CITY OF ALBUQUERQUE

Re: GS 4th LLC
2204 Menaul Blvd NE
Traffic Circulation Layout
Architect's Stamp 08-21-17 (H16-D150)

Based upon the information provided in your submittal received 08-16-17, the above referenced plan cannot be approved for Building Permit until the following comments are addressed:

TRAFFIC CIRCULATION LAYOUT PLAN

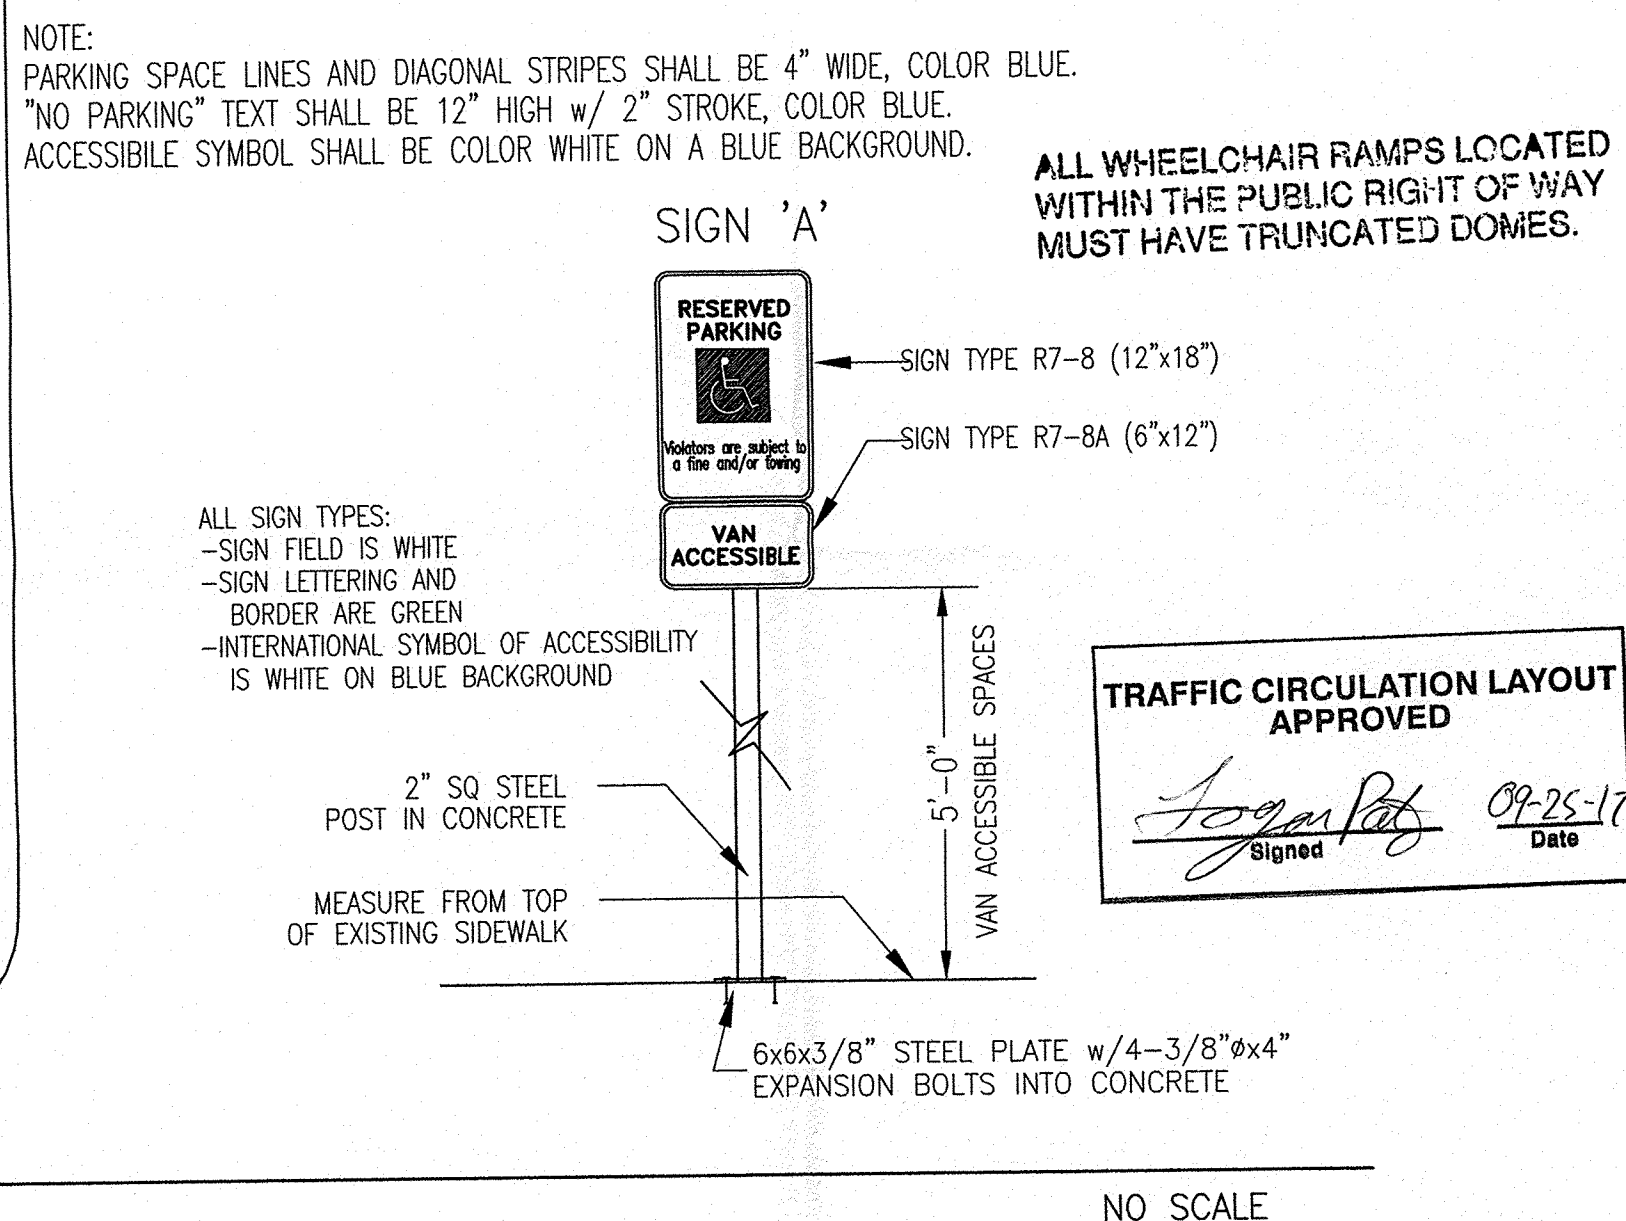
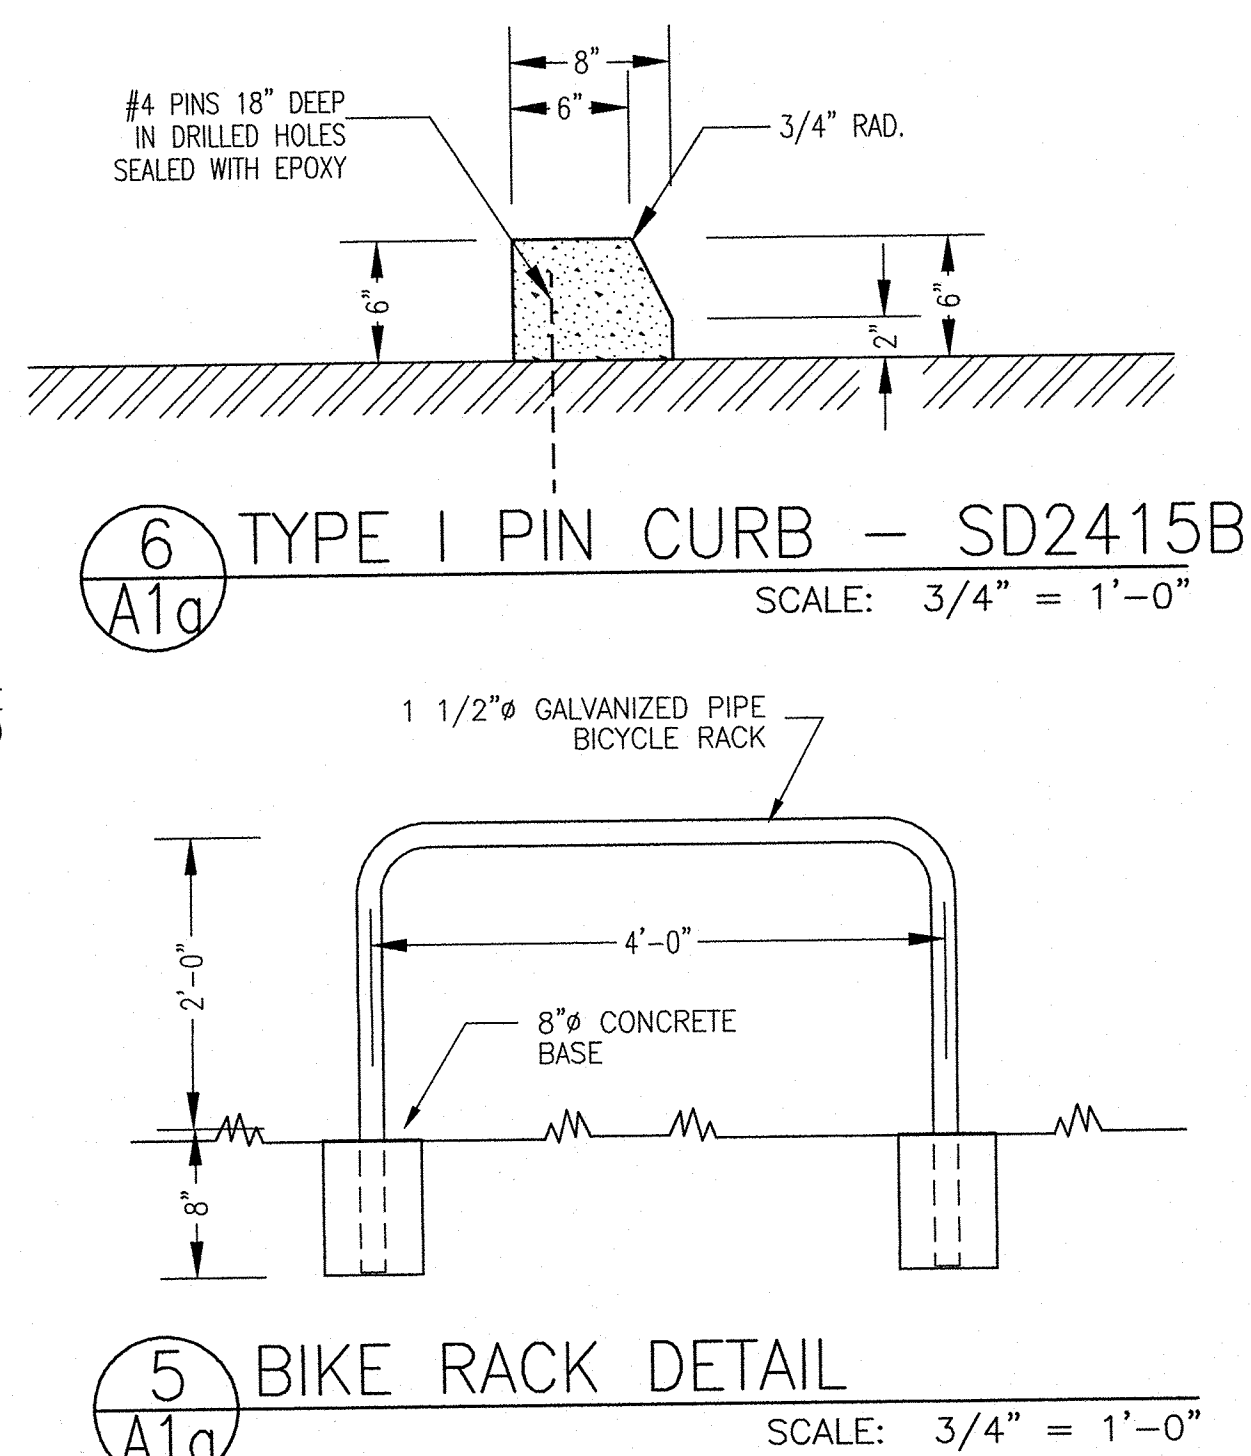
1. Please show a vicinity map showing the location of the development in relation to streets and well known landmarks. The map on the TCL should show the nearest cross street.

2. List the number of parking spaces required by the zoning code as well as the proposed number of parking spaces including bicycle and motorcycle parking. The parking calculations for the restaurant do not follow the requirements in the zoning code, please revise.

3. Please list the width and length for all existing and proposed parking spaces. Some dimensions are not shown. Parallel parking should follow the DPM requirements. The motor cycle and employee parking spaces are missing dimensions.

4. Show all drive aisle widths and radii. Some dimensions are not shown. Dimension the width from the back and sides of the building to the edge of usable pavement.

5. Per DPM, a 6 ft. wide ADA accessible pedestrian pathway is required from the HC parking stall access aisles to the building entrances. Please clearly show this pathway and provide details. Please show the ADA path from the accessible parking to the entrance with slope limits.

6. Service vehicle and/or refuse vehicle maneuvering must be contained on-site; provide a copy of refuse approval.
7. One-way vehicular paths require pavement directional signage and a posted **"Do Not Enter"** sign at the point of egress. Please show detail and location of posted signs.

8. Add a note stating "All broken or cracked sidewalk must be replaced with sidewalk and curb & gutter." A build note must be provided referring to the appropriate City Standard drawing.
9. We would like to see curbing around the parking at the north front of the site. Especially by the pedestrian connection.
